From: Anita Gardner
Sent: 25 February 2014 09:13
To: 'PETER SHAW'
Subject: FW: Application: LU/350/13 46 Pier Road, Littlehampton

From: Geoff Bond
Sent: 24 February 2014 17:10
To: Anita Gardner
Cc: Juan Baeza; Nat Slade
Subject: Application: LU/350/13 46 Pier Road, Littlehampton

Drawing:
Proposed floor plan

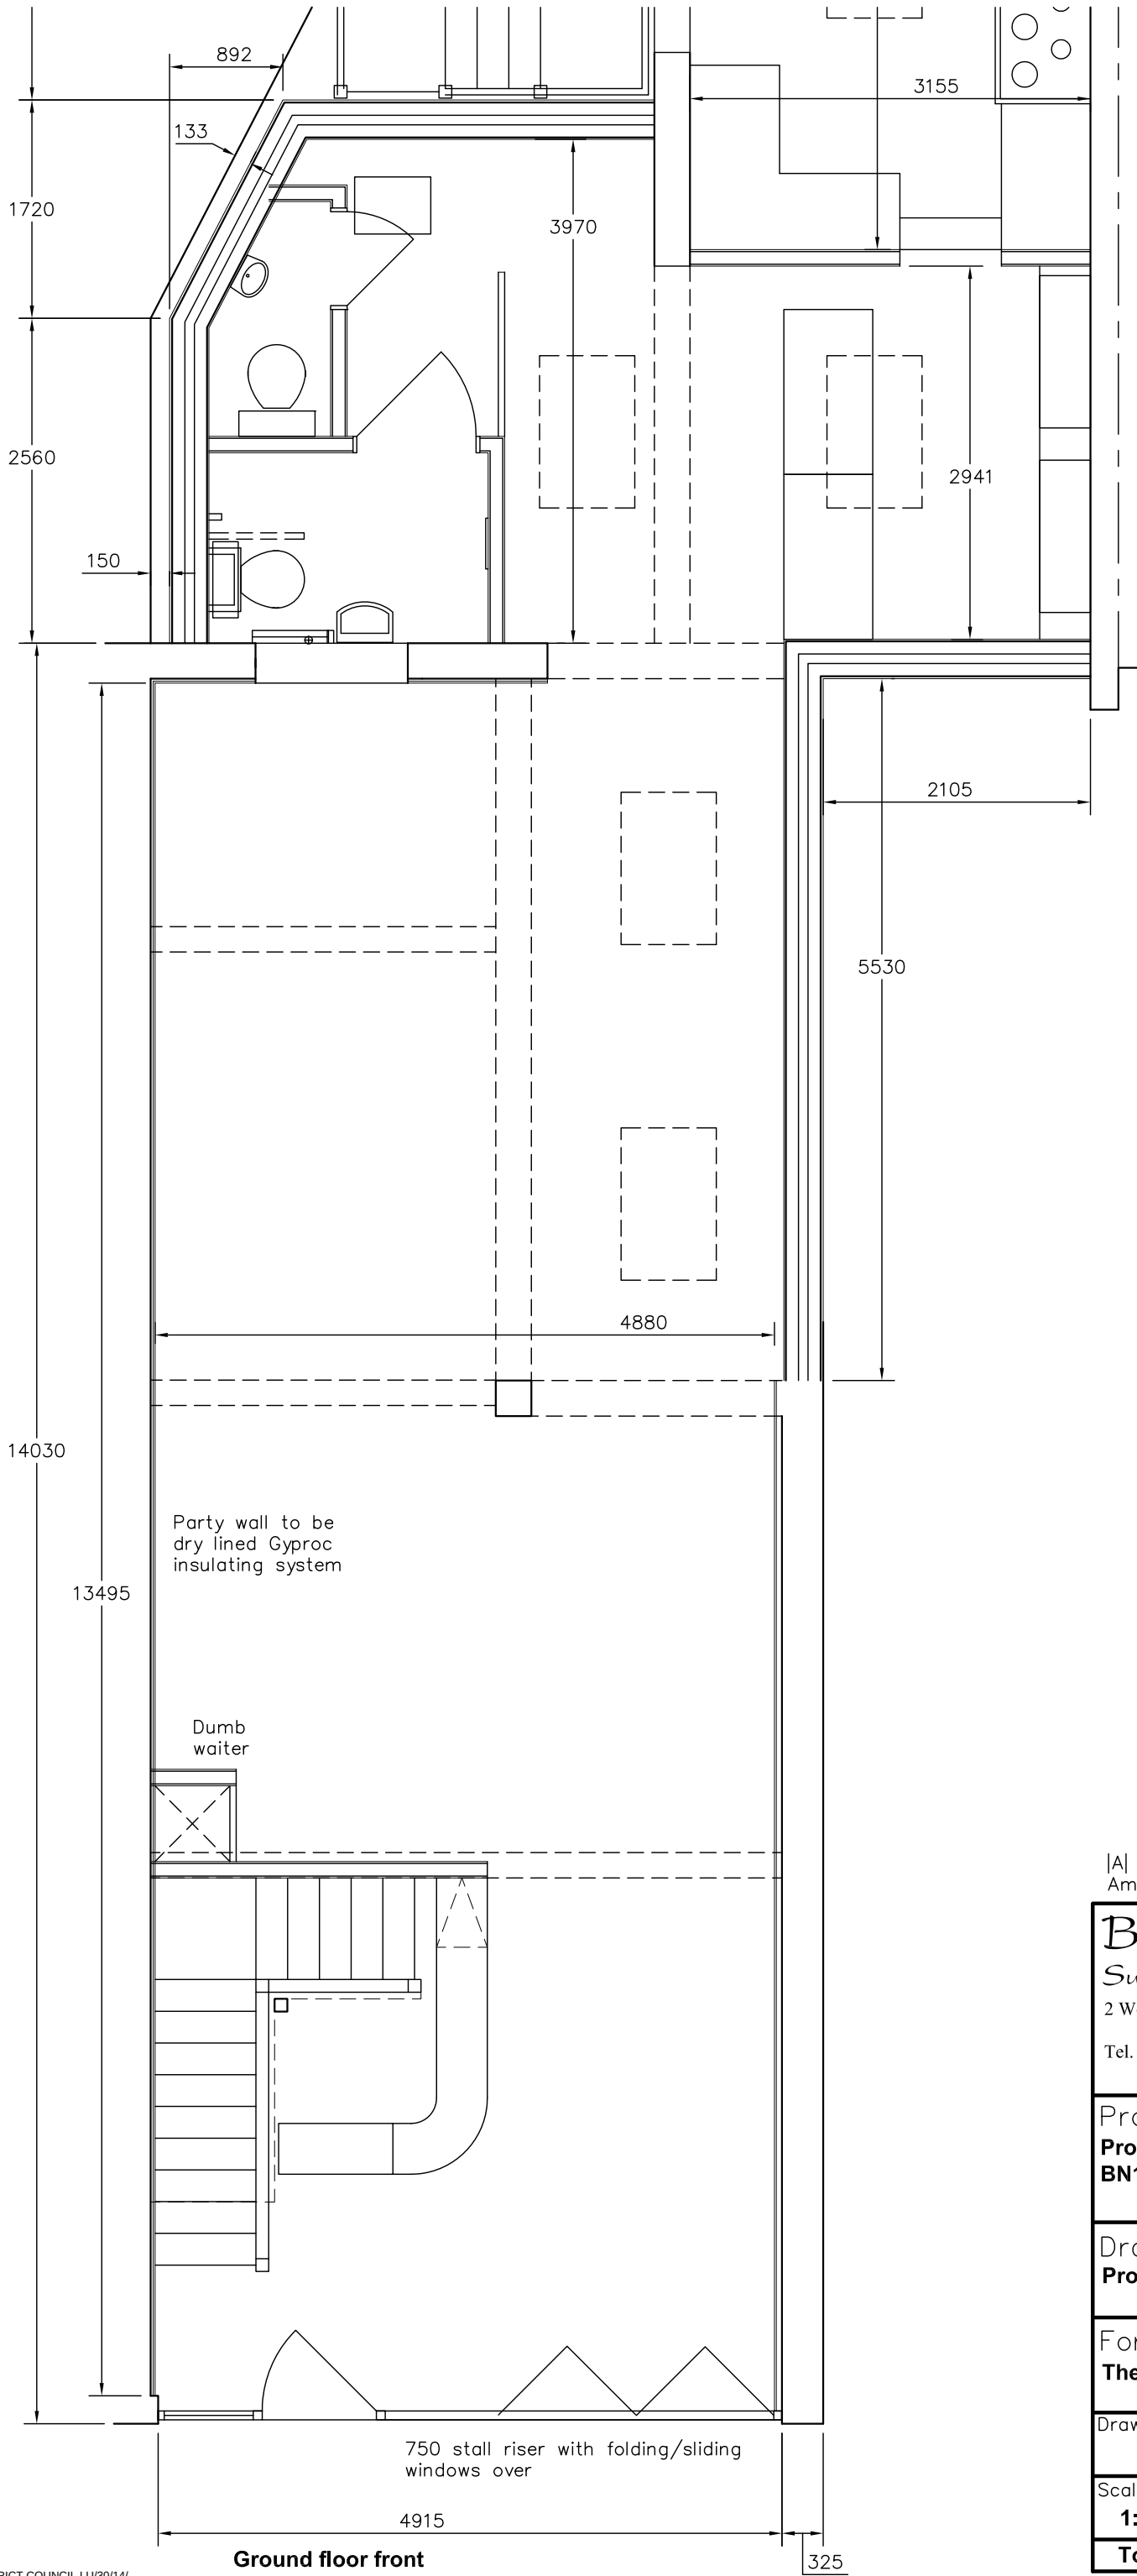
Whilst these are 'existing' food premises, the proposals are significant changes to the layout, kitchen, toilets and numbers of customer seating, the proposed food operation differs considerably from the previous 'fish & chip' restaurant. When examining the plans I could not see any extract ventilation system, which they would clearly need in the kitchen. On previous applications at this address (LU/20/12 & LU/173/12) the applications for an extract system was refused.

If there has not been an application, then the applicants have overlooked this issue and would need to provide the relevant details and data to support the installation of a new system at these premises. Whilst not wishing to add to the applicants frustrations, I feel that they must be advised of these requirements to enable their plans to be amended promptly and to prevent any long term noise or odour issues which may be at risk to the amenities of the area.
